**WEST SUSSEX COUNTY COUNCIL
STRATEGIC PLANNING CONSULTATION**

SUBJECT: Y/76/17

Discharge of conditions 9 – secure cycle spaces, and 11 – Construction Management Plan

client: PLOT LIFE SPV3 LTD date: Nov 2017 scale: 1:50 @ A3
project: LAND AT KINGS CLOSE YAPTON drg no: 16024-RM115 status: reserved matters application

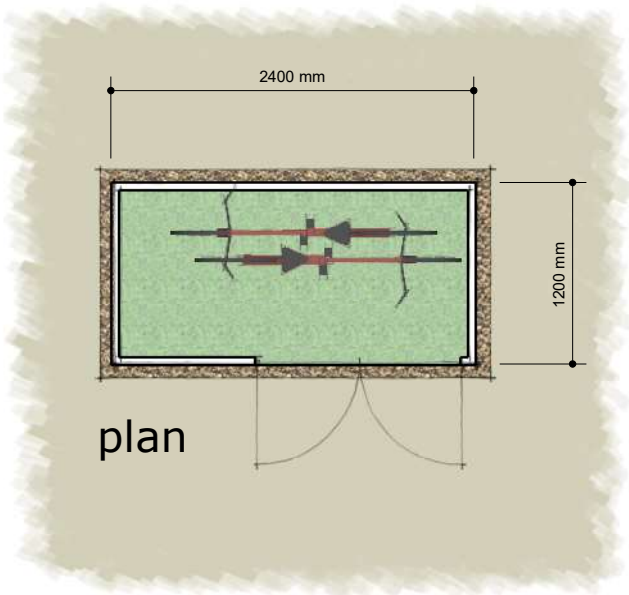
**Plans of secure sheds holding up to 2 cycles have been submitted. (drg no 16024-RM118)
Discharged**

date **OCT 2017**
drg no **16024-RM101-SCHEMATIC-23.10.17**

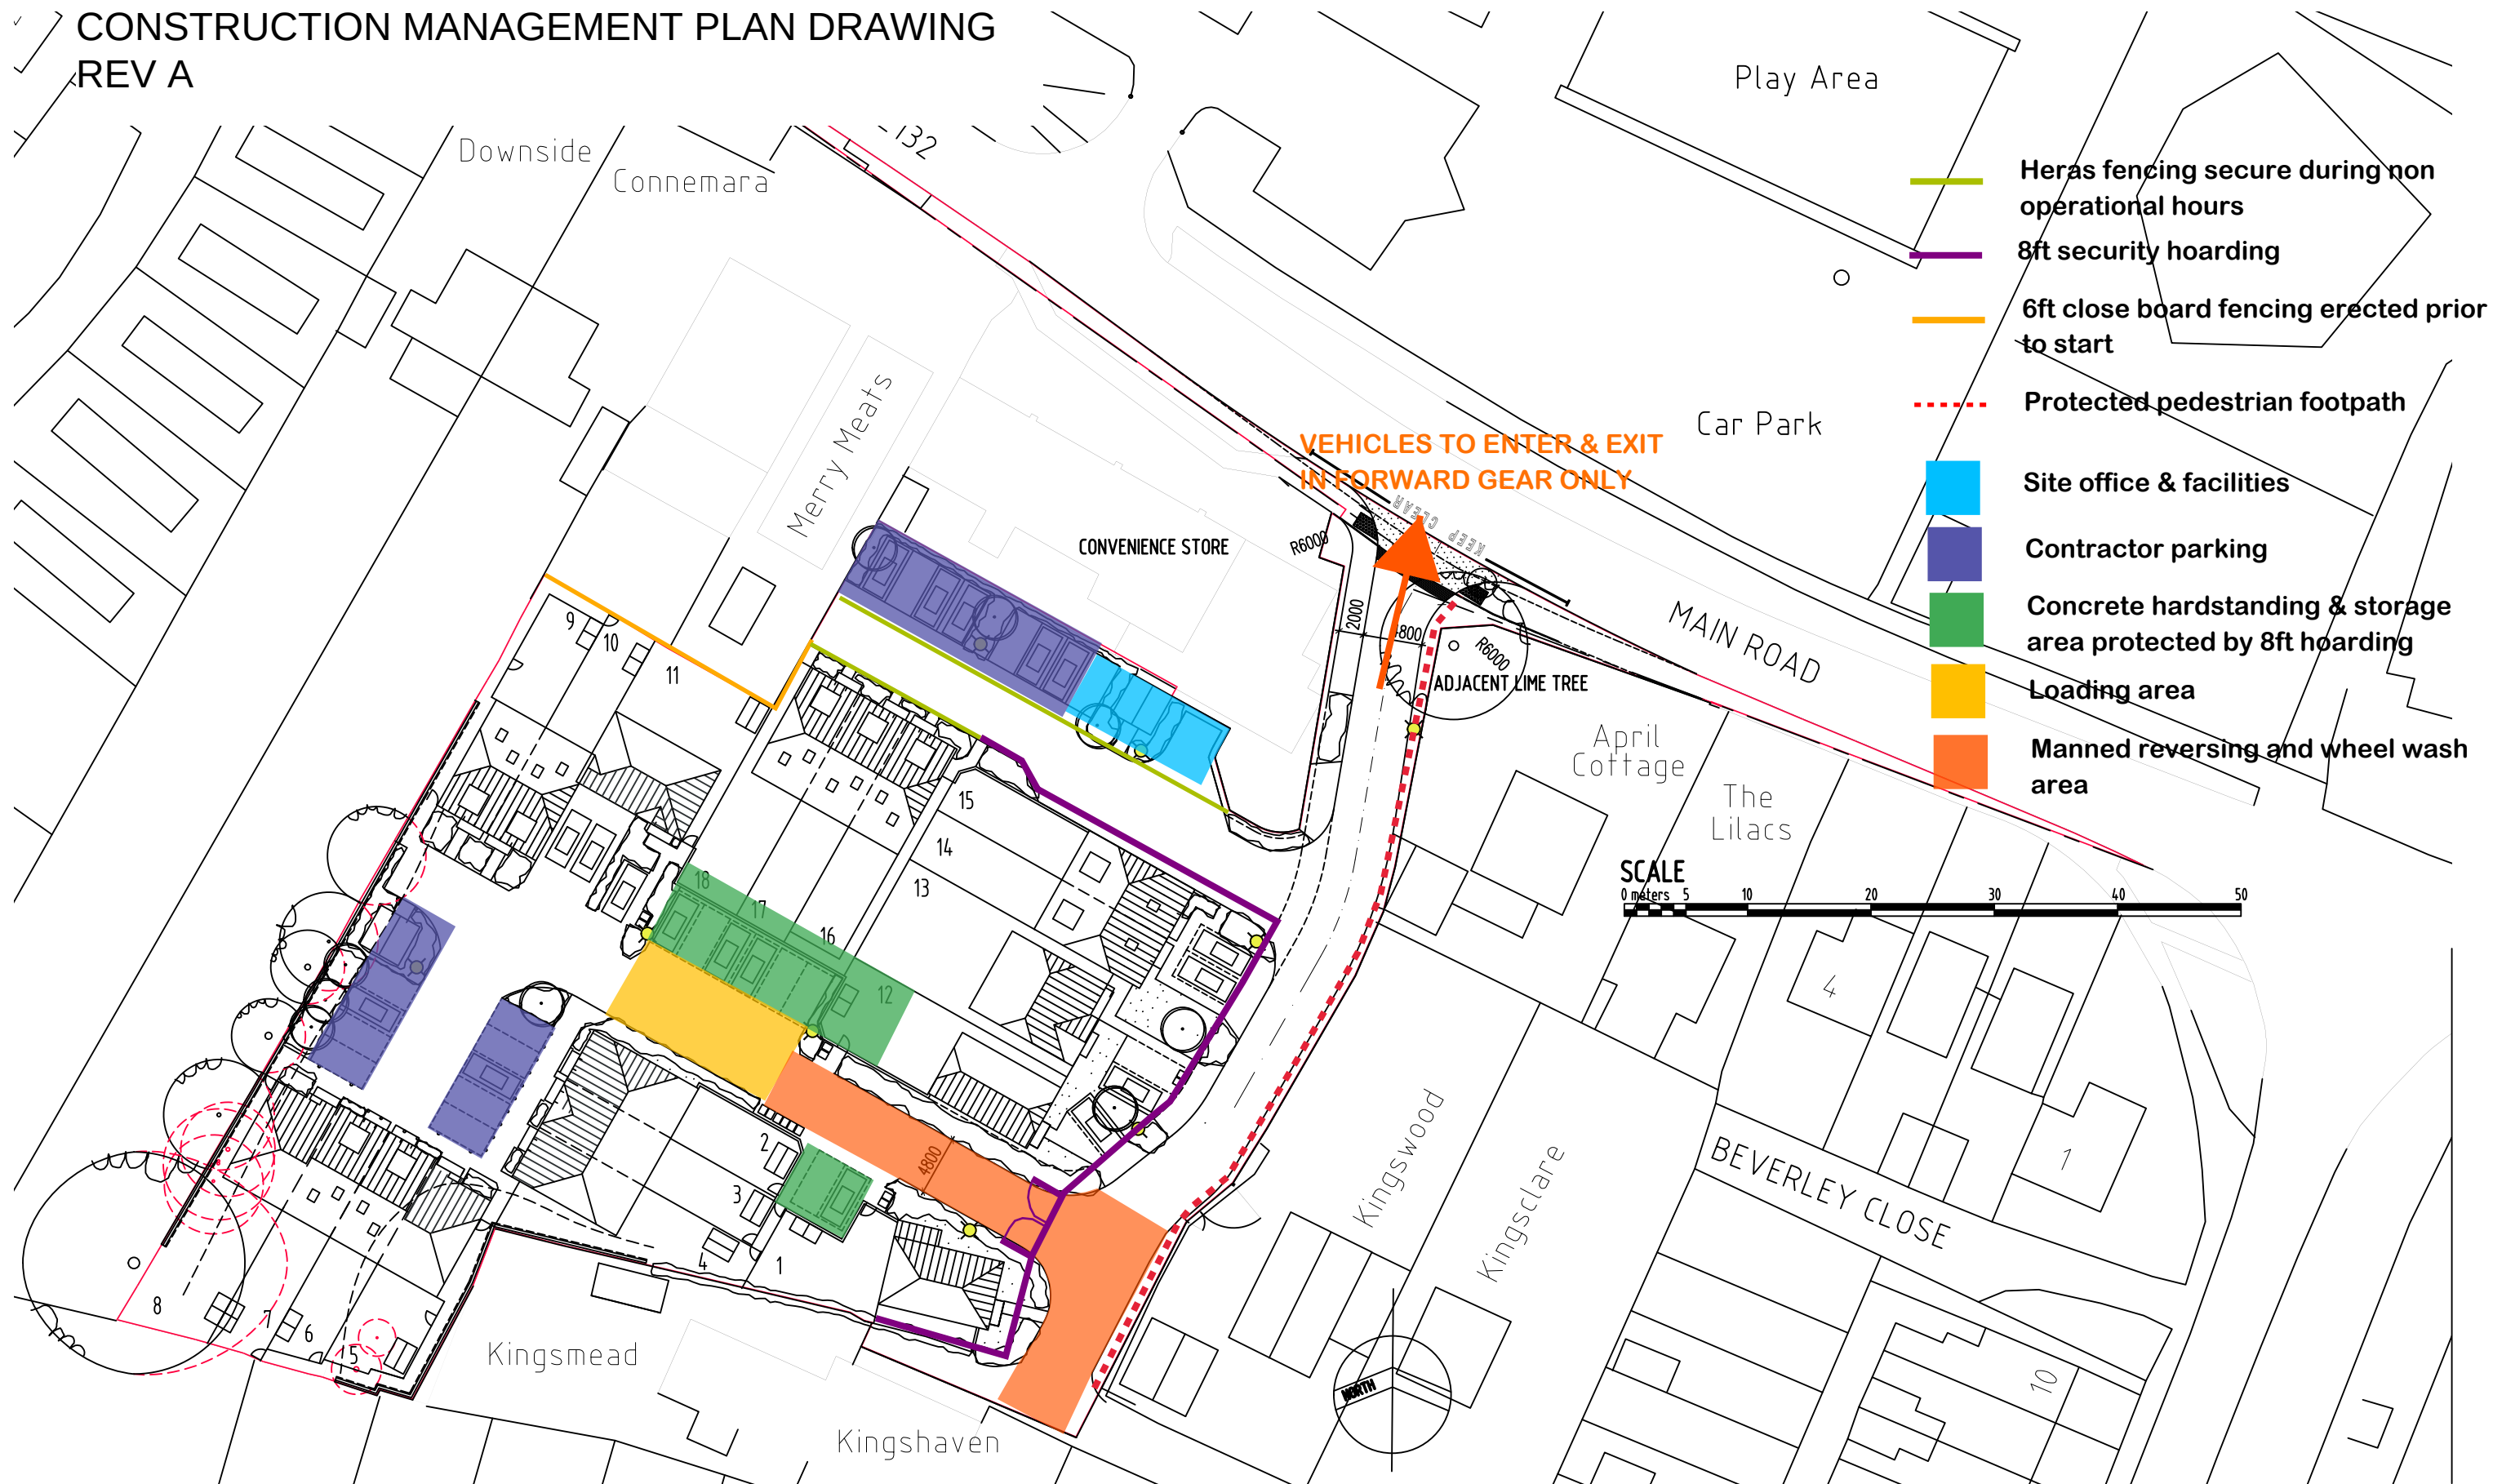
**Construction management plan drawing 16024 –RM101 Schematic 23.10.17
Discharged**
